Markup Summary

Subject: Callout
Page Label: [1] COVER SHEET
Author: dsdparsons
Date: 6/3/2019 11:09:19 AM
Color: ■

TRACT DETAILS

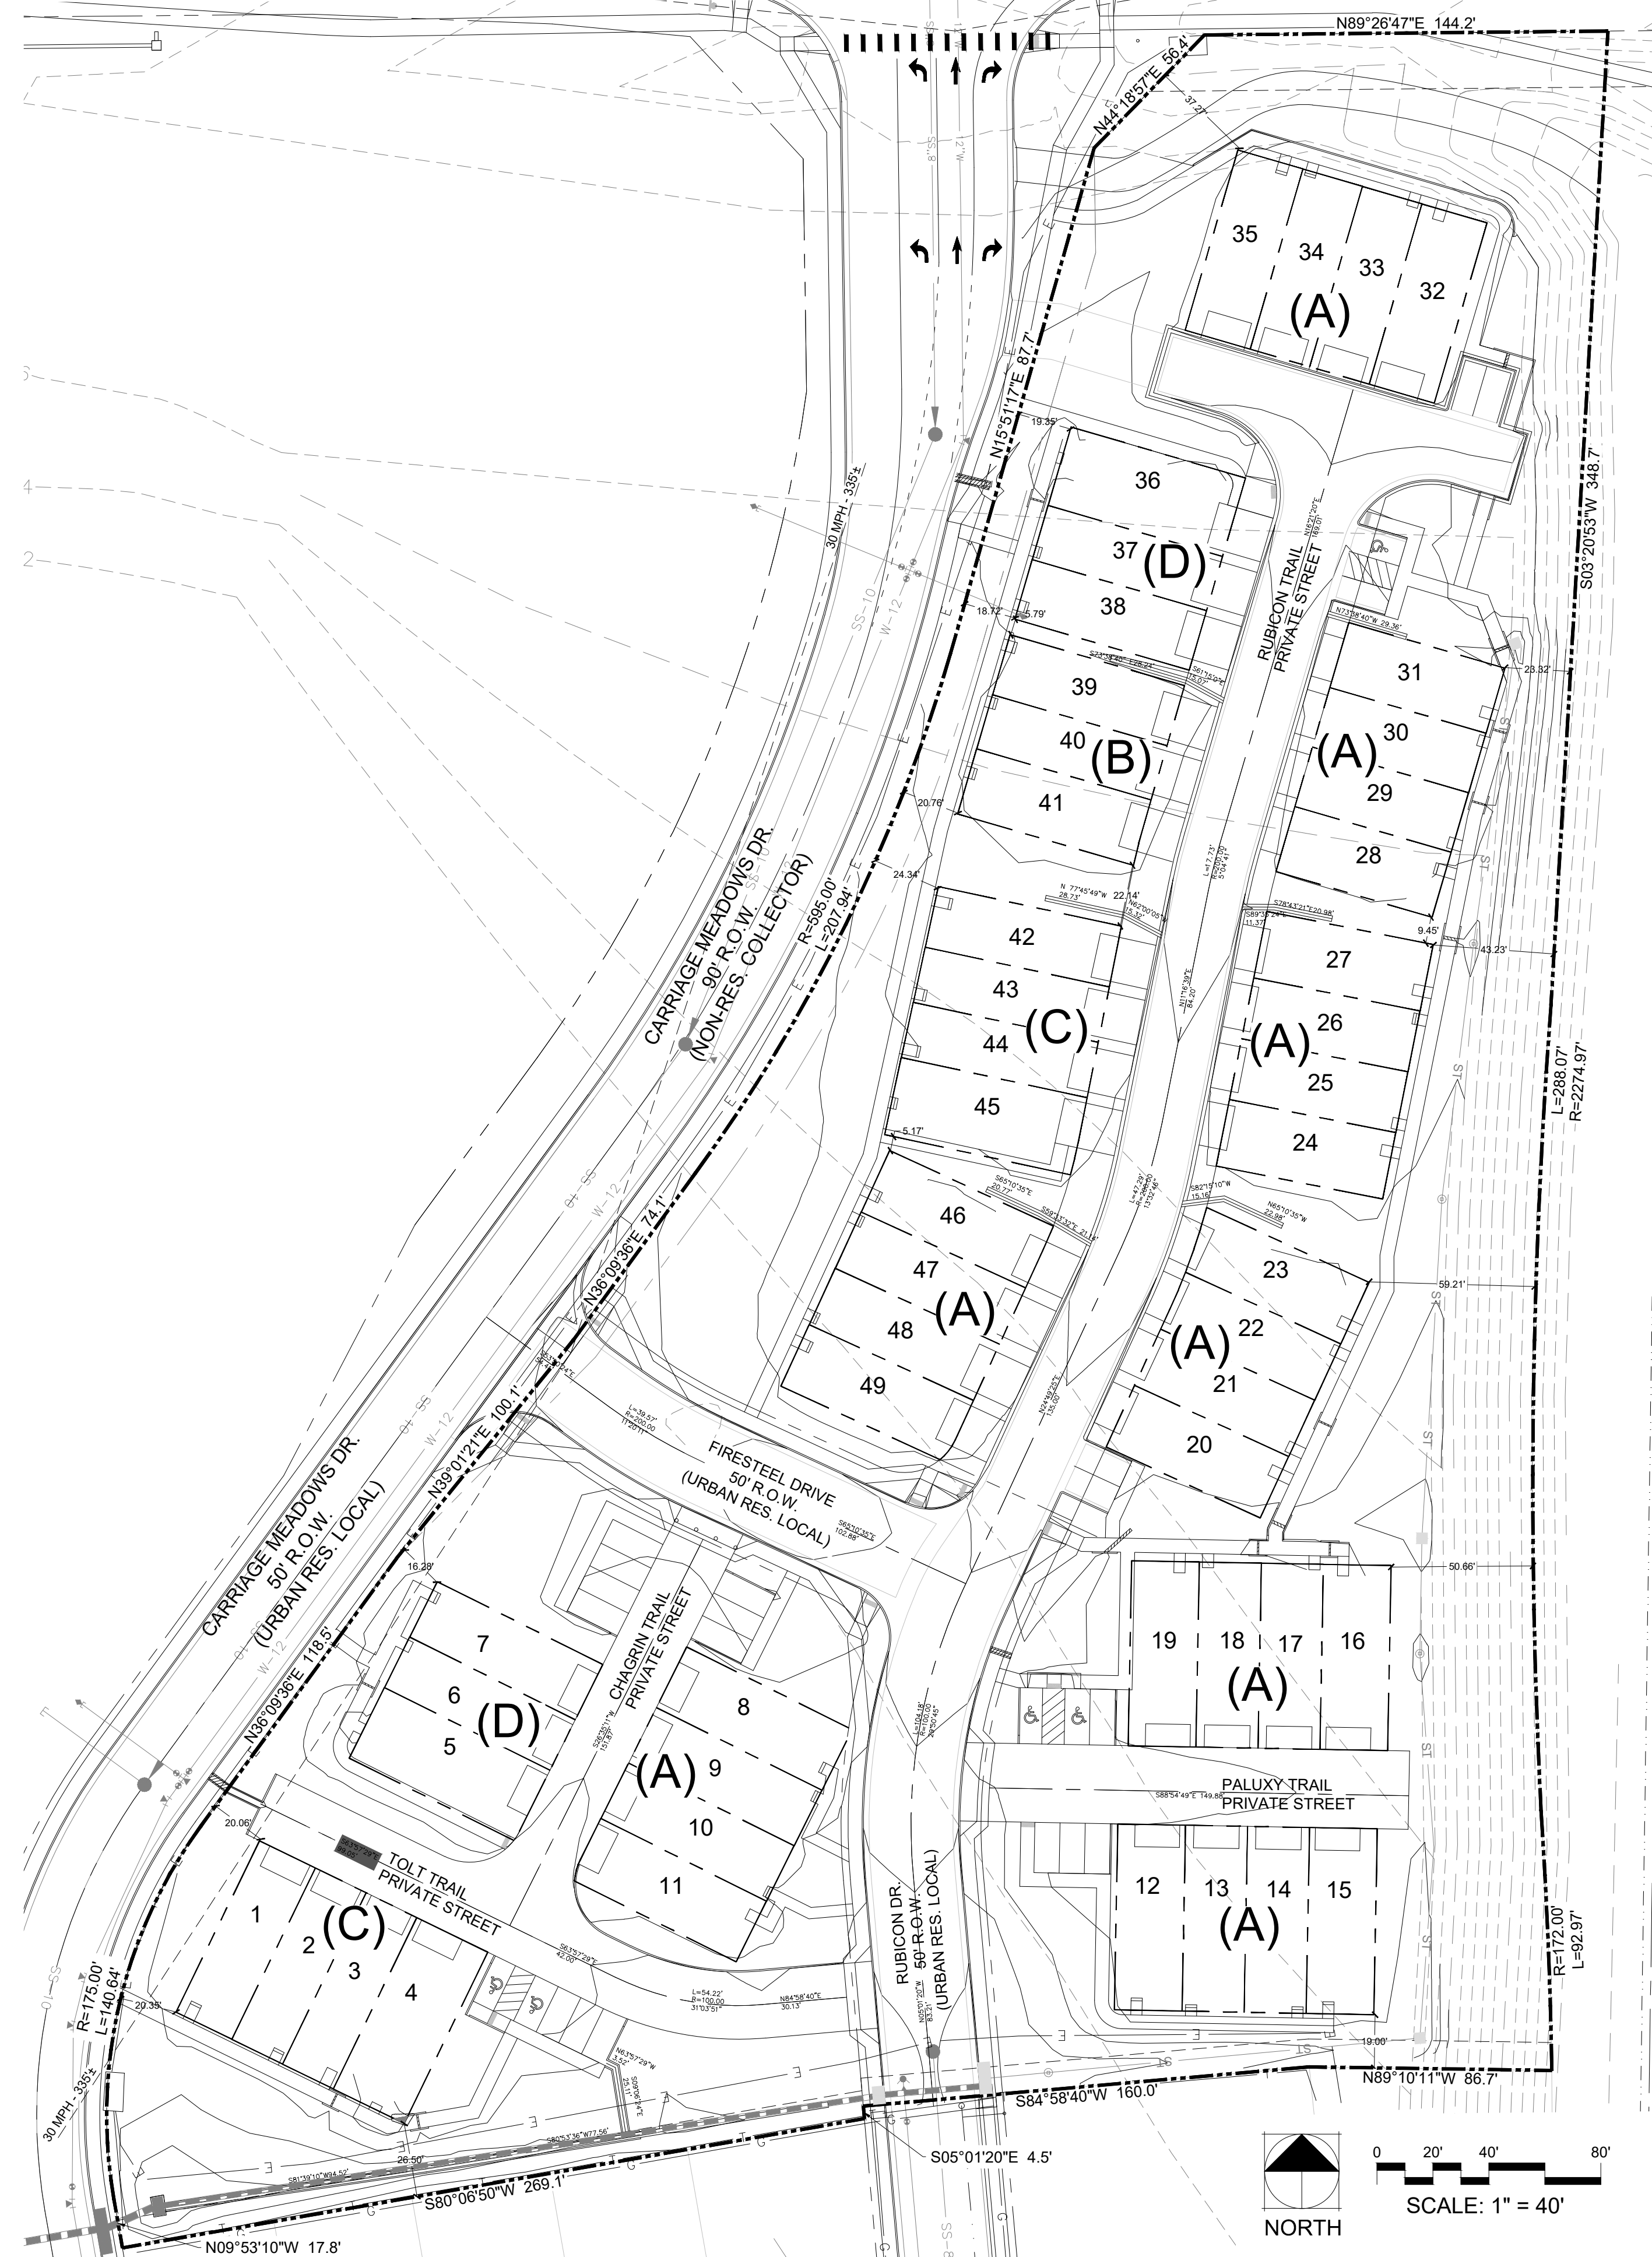
Cars may not hang over driveisles or roadways. A PUDMod may be needed- please see standrds in Chapter 6.

Are these lot lines? Depict the lot lines with one line type and label.

Parking may cause a public safety concern. Provide a specific letter that the Fire protections district has no issues with on site street parking and length of driveway as an overhang will block

Provide a parking table: Justify the parking; identify how many bedrooms, and how many spaces included in garage and in a 10 foot driveway plus guest parking areas.

NO MIDIFICATION NEEDED. APARKING IS PROHIBITED IN DRIVEWAYS LESS THAN 20 IN LENGTH. DRIVEWAYS ARE NOT INHERENTLY PARKING SPACES, UNLESS DIMENSIONS AND PLAN AUTHORIZE.

PER RESPONSE FROM SECURITY FIRE, THE PARKING DOES NOT CAUSE PUBLIC SAFETY CONCERN. DRIVEWAYS LESS THAN 20 IN LENGTH ARE NOT INHERENTLY PARKING SPACES, UNLESS DIMENSIONS AND PLAN AUTHORIZE. PARKING/VEHICLE STORAGE, ONLY AS MEANS OF INGRESS/EGRESS FROM DESIGNATED GARAGE SPACE TO PRIVATE DRIVEWAYS.

PARKING TABLE PROVIDED

ZONED: PUD
VACANT

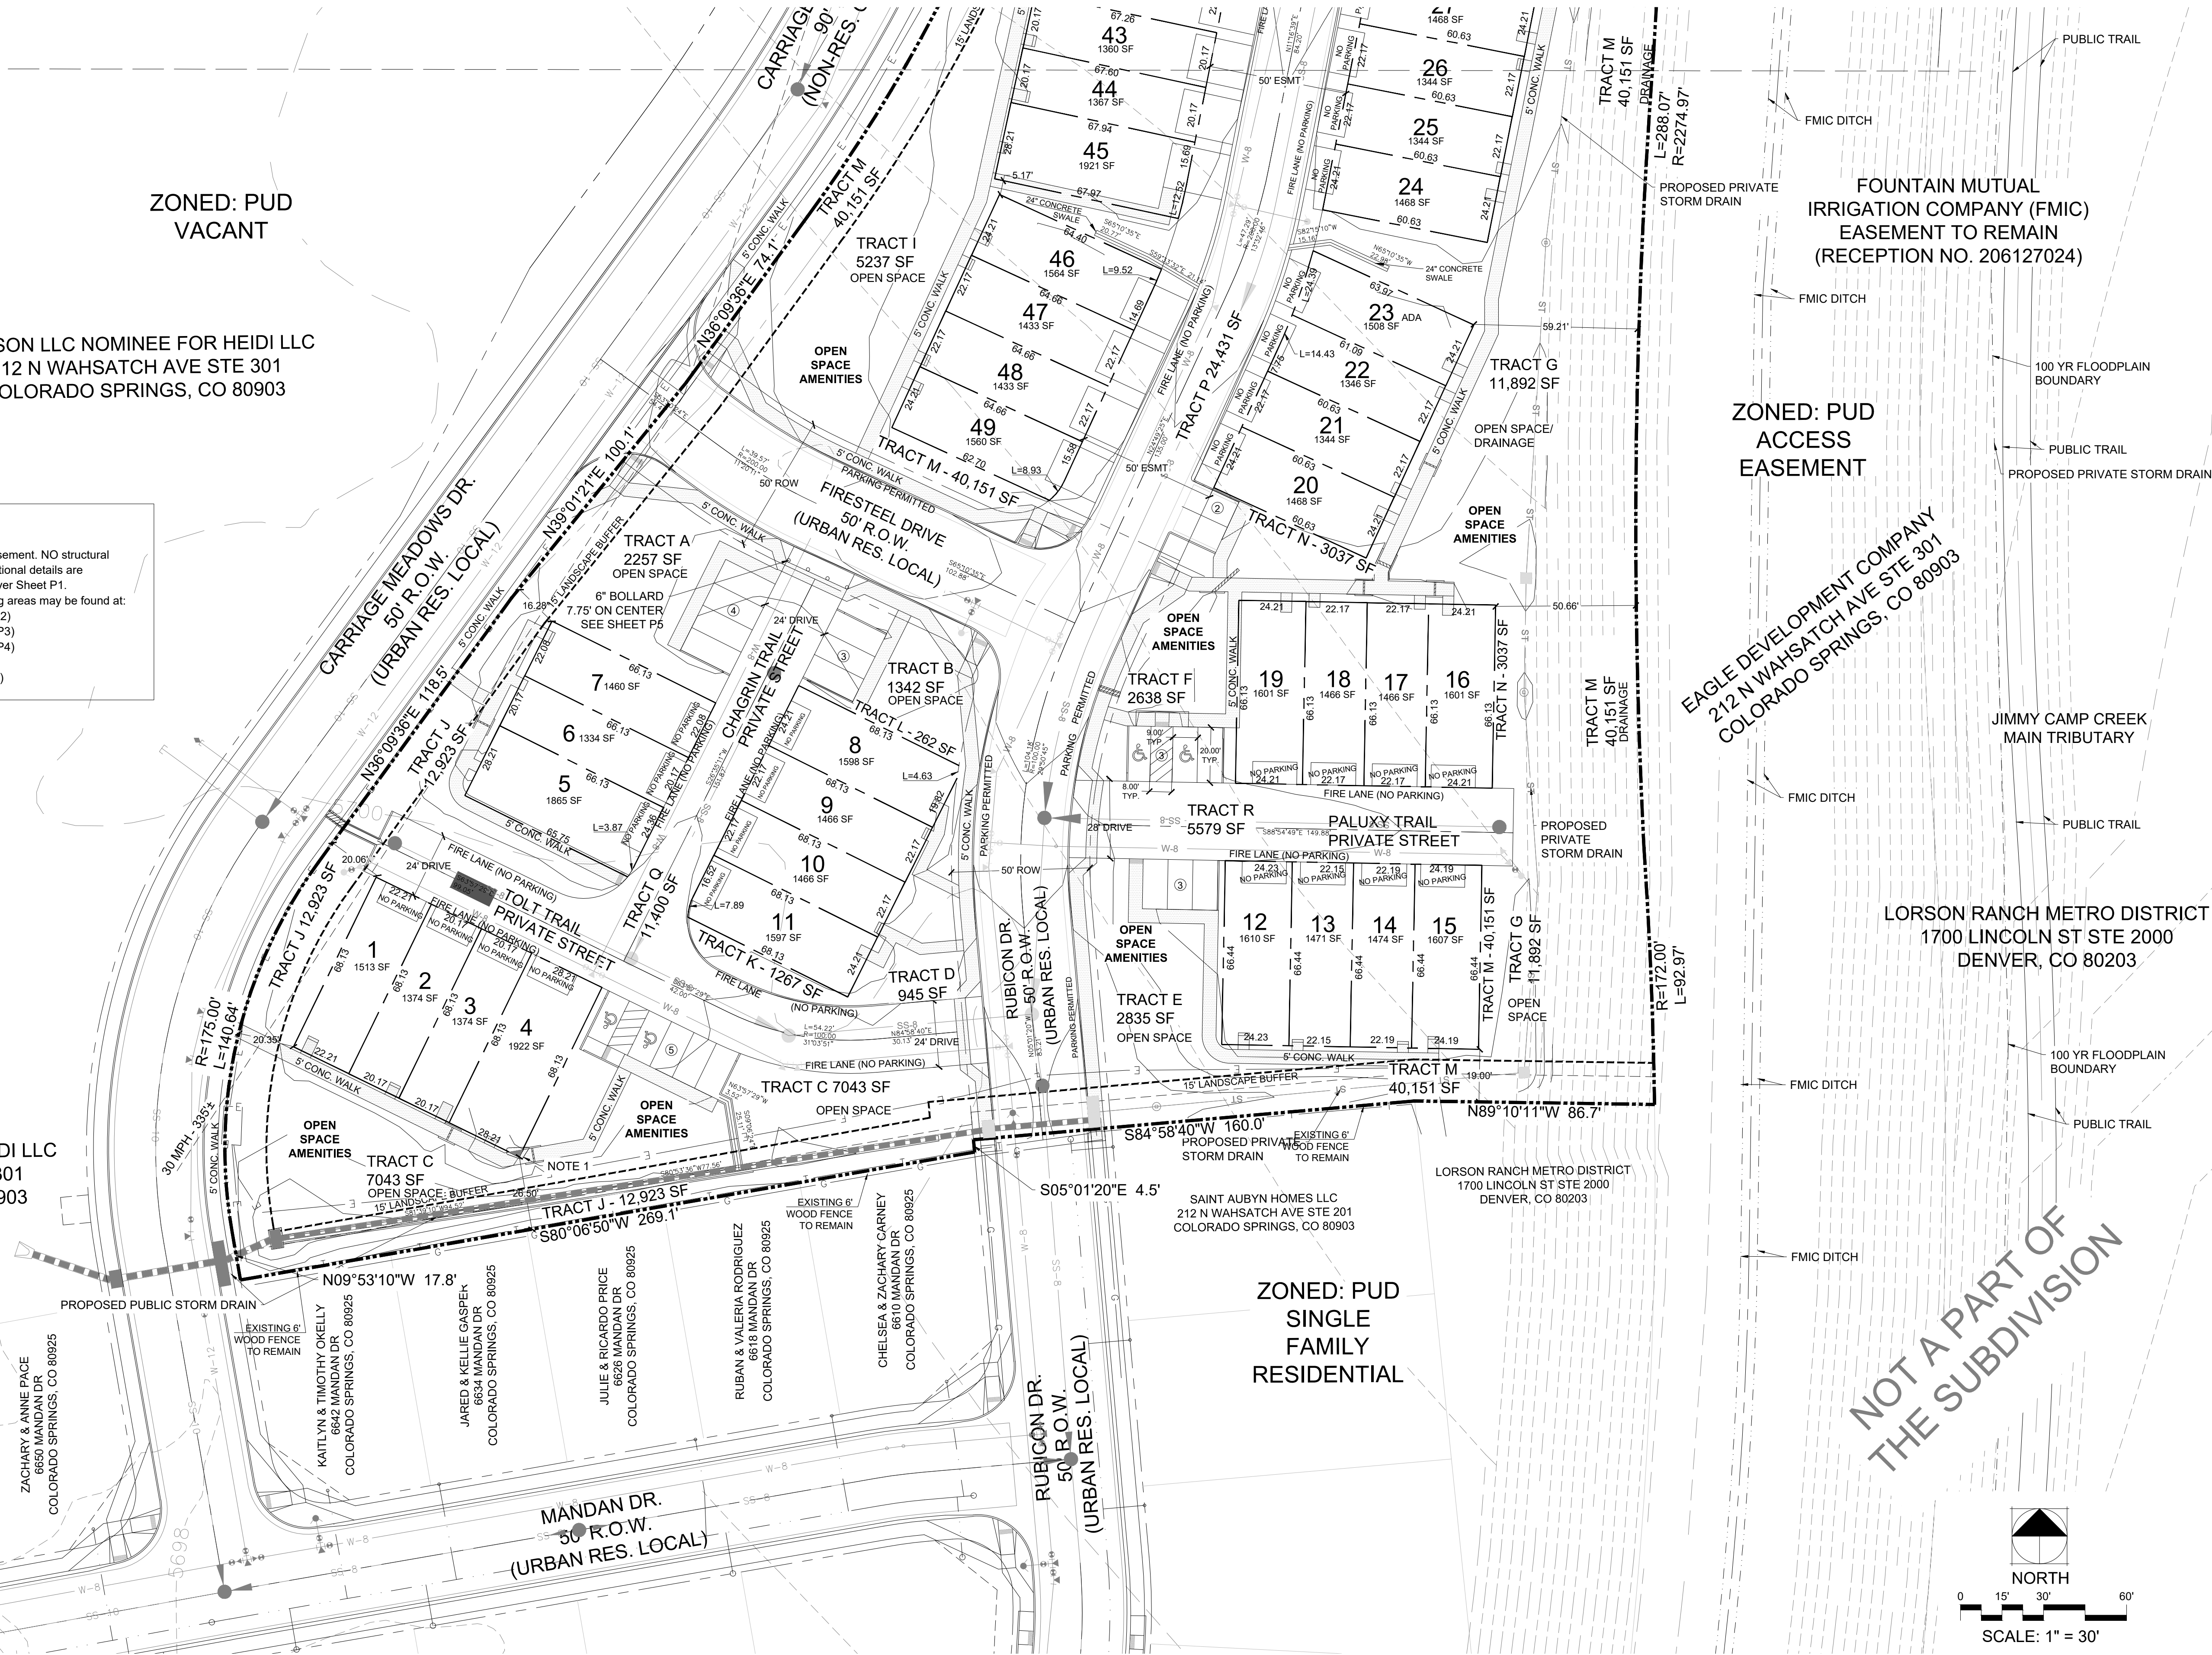
remove the utilities since you have a sheet 4 identifying them

remove interior footprints; you do not want to make that zoning because any changes would be an amendment; just show the lots and identify a detail typical- (include driveway lengths) Dimensional standards should be included in the development standards.

the actual lot lines are not clear-please adjust so all internal lot lines and tract lines are clear and dimensioned.

please identify the sidewalk along the ROW.

width and Centerlines of roadways required

delete the utilities
- show easements existing and proposed

there is not a ten foot landscape setback identified- bldgs appear to be within it.

REVISED.

REVISED.

REVISED.

NO SIDEWALK IS PLANNED AT THIS LOCATION DUE TO DESIGN OF BRIDGE WITH SHOULDER SPACE FOR SIDEWALK ON NORTH SIDE ONLY.

REVISED

REVISED

REVISED
